## NSW RURAL FIRE SERVICE

Your reference: SSD 9210  
Our reference: D18/7982

### **State Significant Development Application – 2320 & 2321//1223137 – 17-19 Kosovich Place Cecil Park**

**Figure 7 – Asset Protection Zone Plan.**

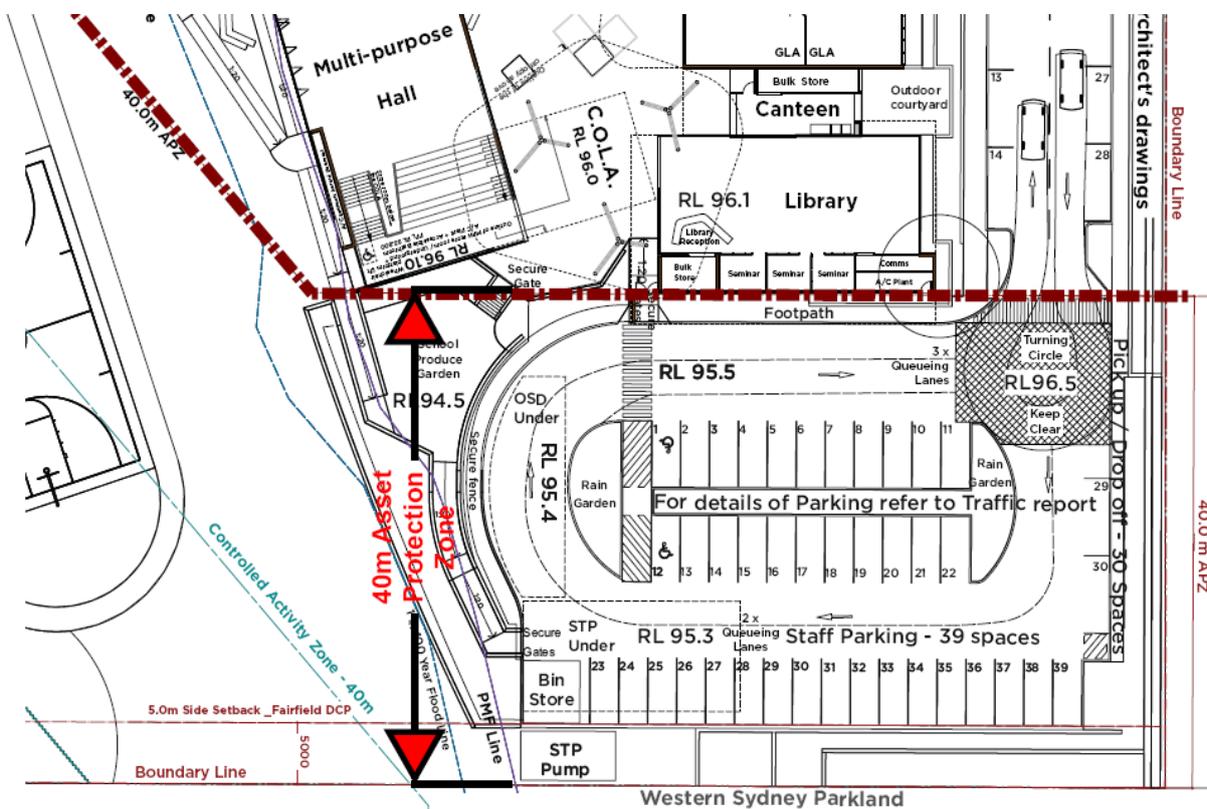
1. At the commencement of building works and in perpetuity the entire property except for the area covered by the vegetation management plan shall be managed as an inner protection area (IPA) as outlined within section 4.1.3 and Appendix 5 of *Planning for Bush Fire Protection 2006* and the NSW RFS document *Standards for asset protection zones*.
